Submission No.			264	
Organisation Name or Name of Submitter			Rethink Metrolink	
Item No.	Section Ref.	Page No.	Observation Statement	TII Response
Letter Re: Observation to ABP on MetroLink Railway Order Case No. NA29N 314724 Estuary through Swords, Dublin Airport, Ballymun, Glasnevin and City Centre to Charlemont, Co. Dublin

TUNNEL ALIGNMENT
SAINT STEPHEN'S GREEN – CHARLEMONT
RO APPLICATION VS DEEPER VERTICAL ALIGNMENT OPTION

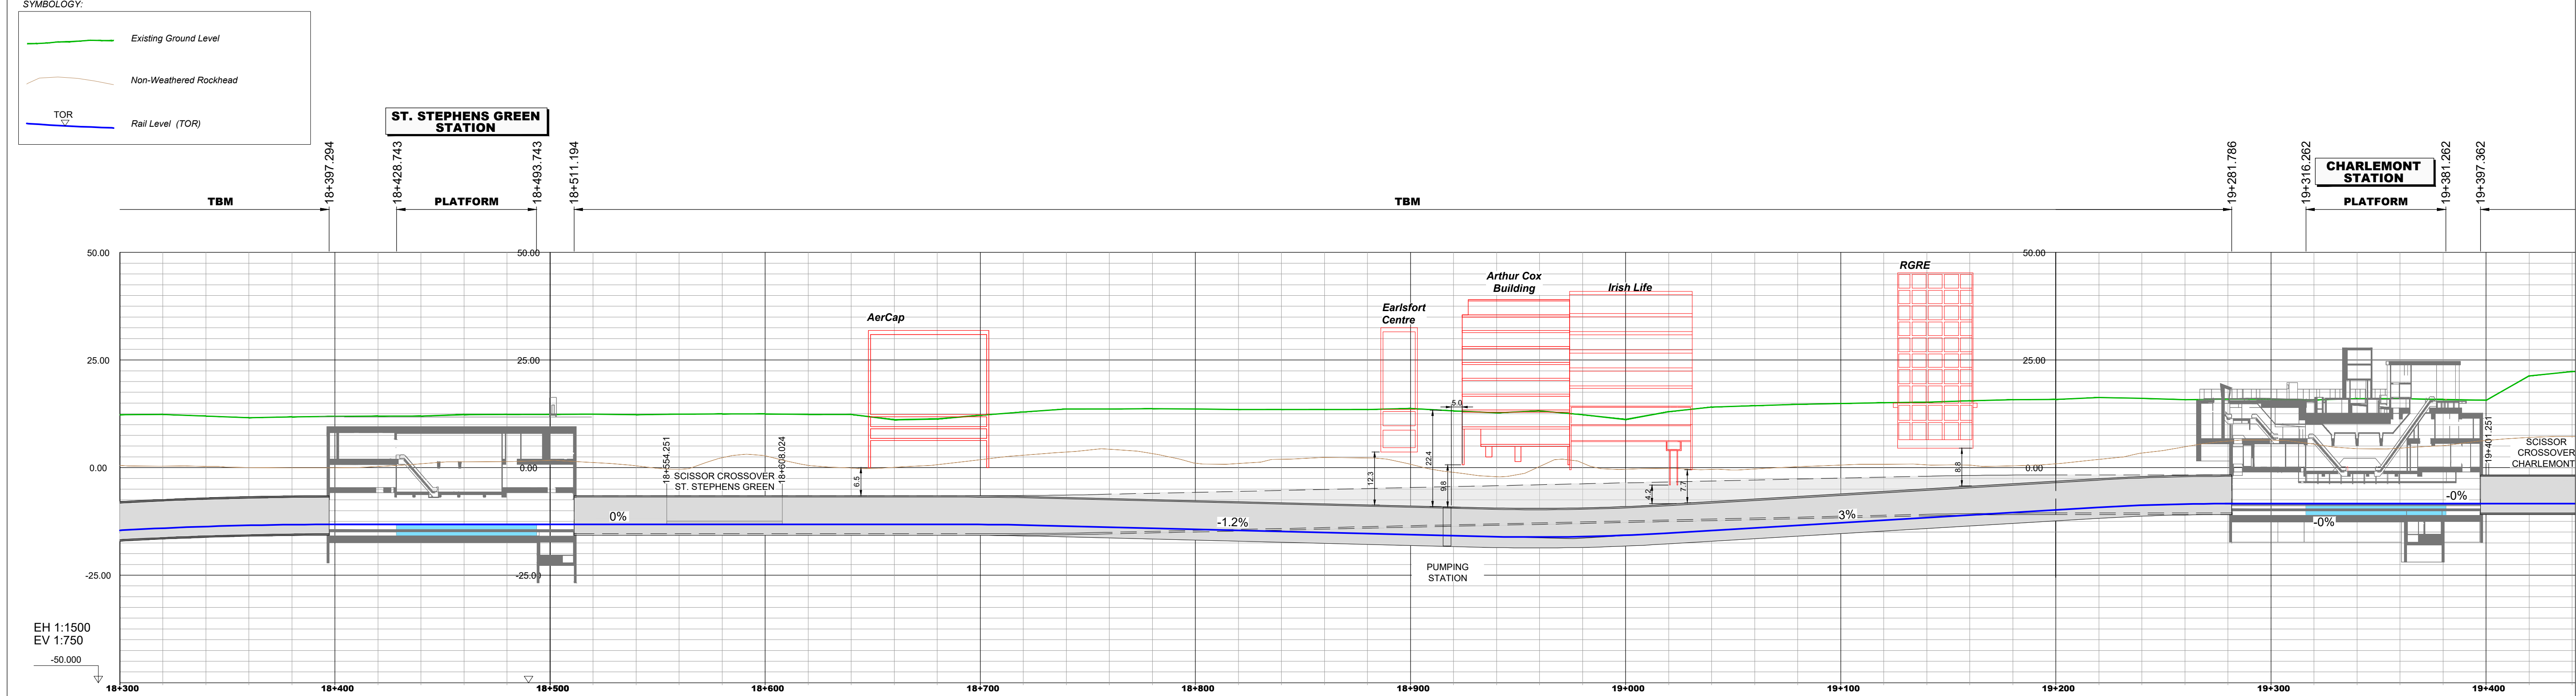
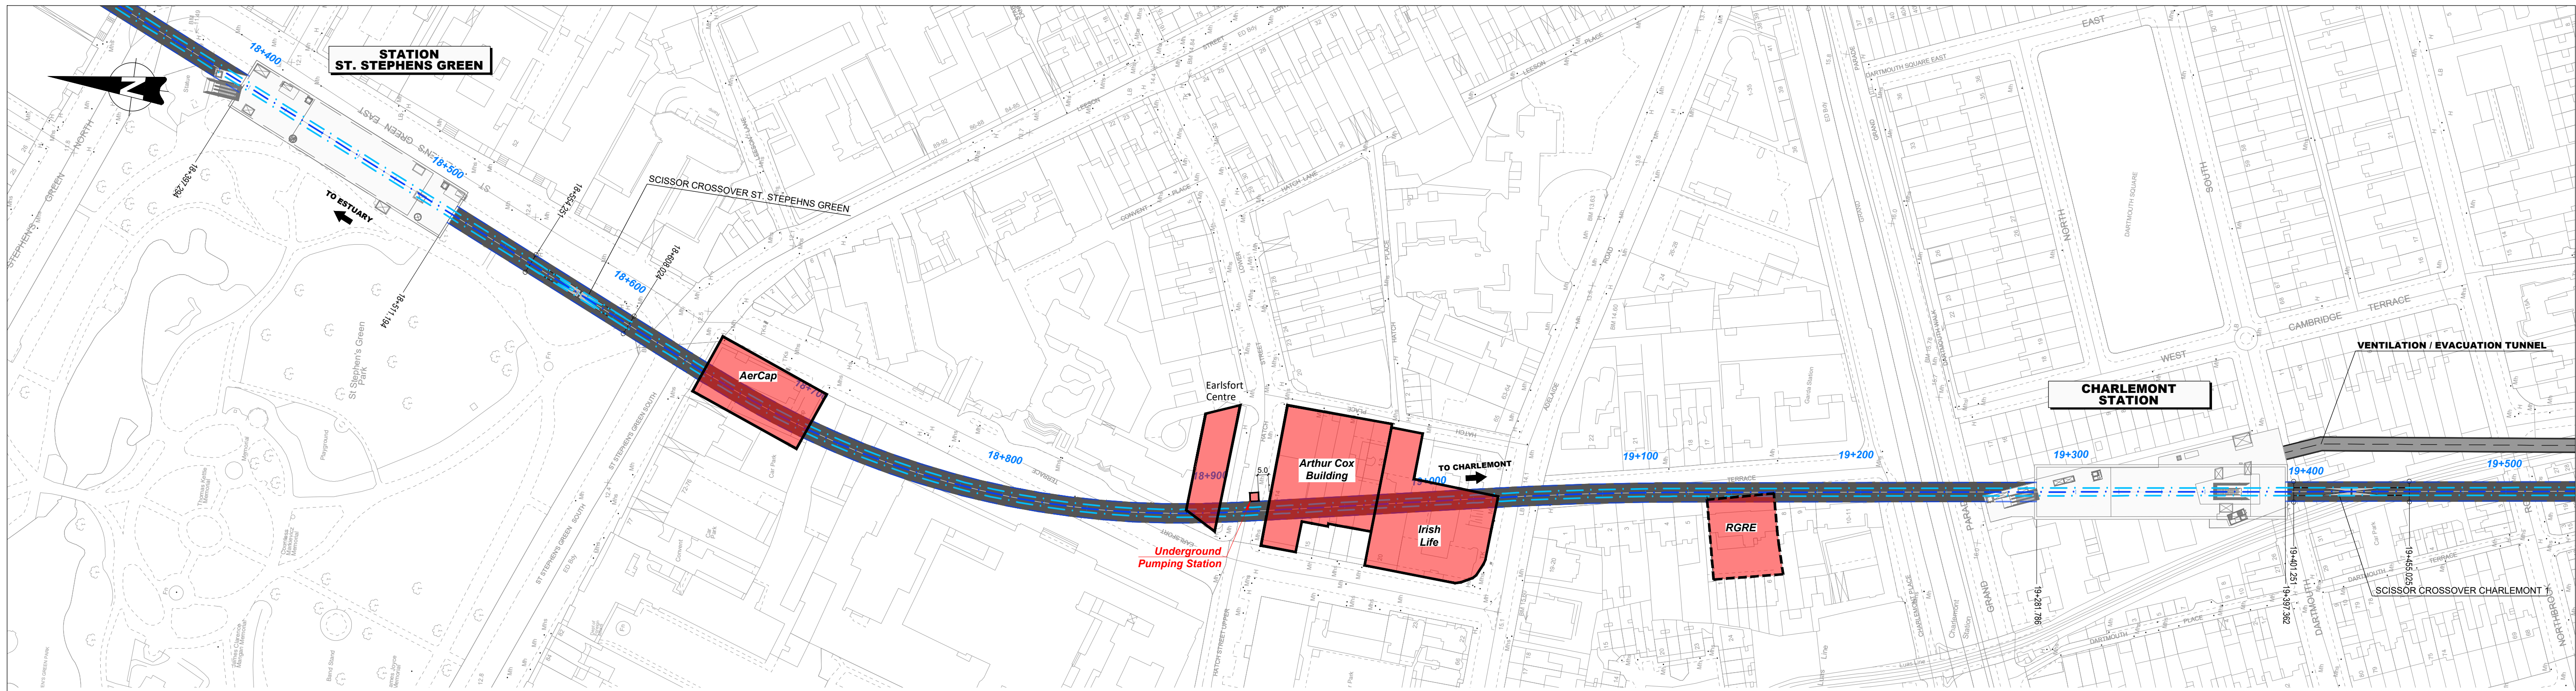
4	2. An Bord Pleanála should approve MetroLink only as far as St Stephens Green	3	We believe that if the tunnel is bored as far as Manders Terrace, it seriously compromises the ability for a southern extension to include the highly populated city suburbs of Portobello, Lower Rathmines, and Harold's Cross. We would submit that proper planning of the project which is the subject of the Railway order requires a full and proper evaluation of the options for extension and that it is not consistent with proper planning to bring Metrolink beyond St. Stephens Green to Charlemont which would compromise the options.	Please refer to response item (1) and (3) above in relation to the reasons for continuing MetroLink to Charlemont.
